Cherwell District Council: Begbroke Science Park, Begbroke Hill, Begbroke, Kidlington, OX5 1PF

On behalf of our client, Oxford University Development Ltd (OUD), please find enclosed an application for a Non-Material Amendment (NMA) to full planning application (Ref. 21/03195/F) (dated 4 February 2022) for:

“Formation of surface car park and service building (including substation, sprinkler tanks and EV charging infrastructure)”.

**CONSTRUCTION DETAILS**

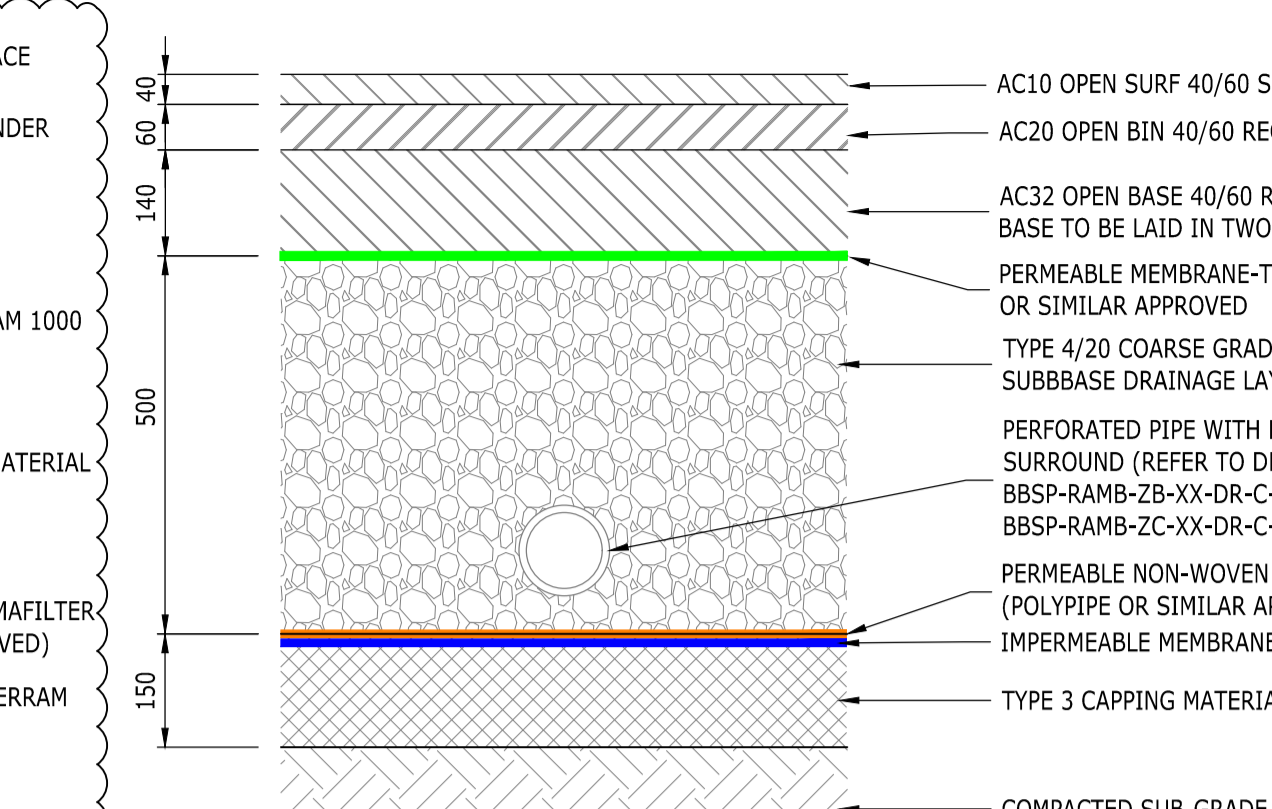
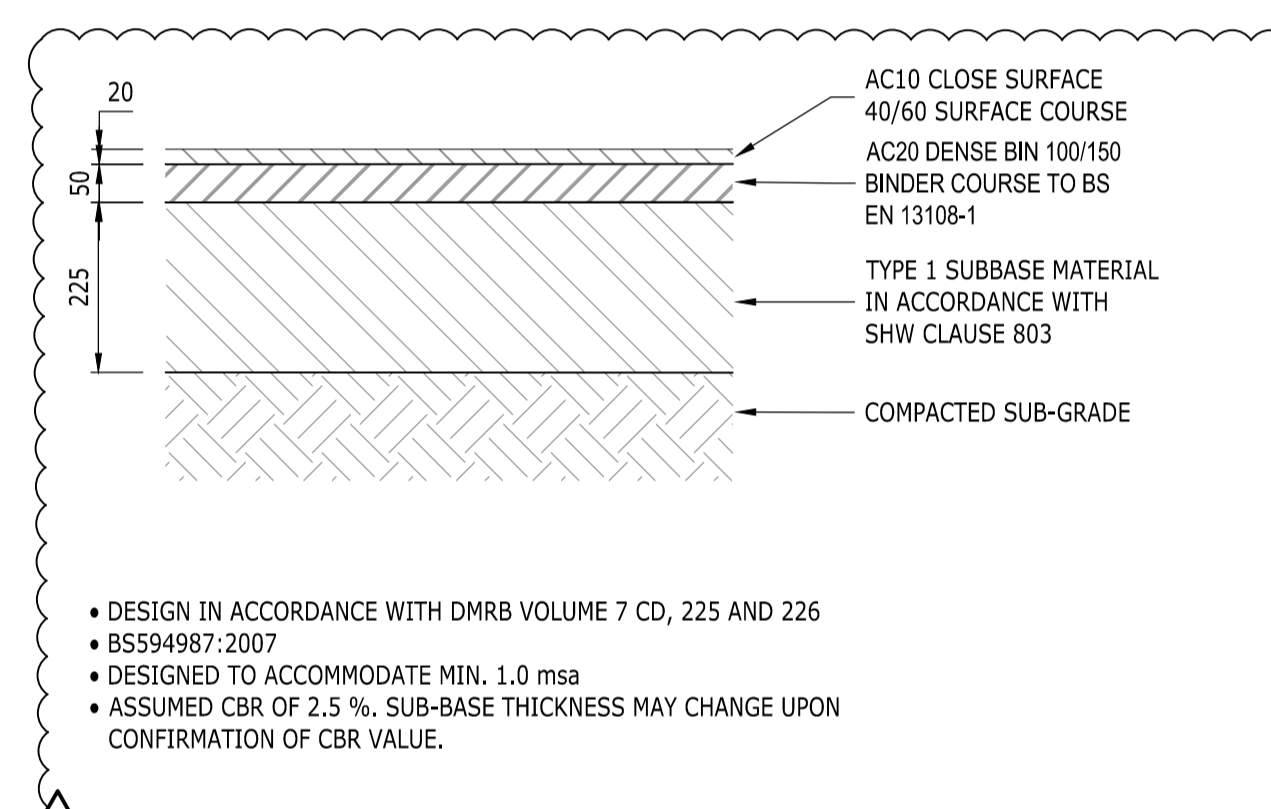
As OUD has progressed with the detailed design of approved application 21/03195/F it has become apparent that there is a need to change the permeable block paving to parking bay surfacing with a porous bituminous macadam surface.

The Non-Material Amendment proposes the substitution of permeable block paving to parking bay surfacing with a porous bituminous macadam surface. This design change is in response to design and technical constraints which have become apparent during the design stages following the planning submission. There have been frequent failures using permeable block paving which also has high maintenance requirements therefore porous bituminous macadam surface is considered a more appropriate solution.

Overall, the proposed new surface material to the parking bays will ensure that an alteration to the surface material will have minimal impact on the proposed development’s water management and drainage strategy.
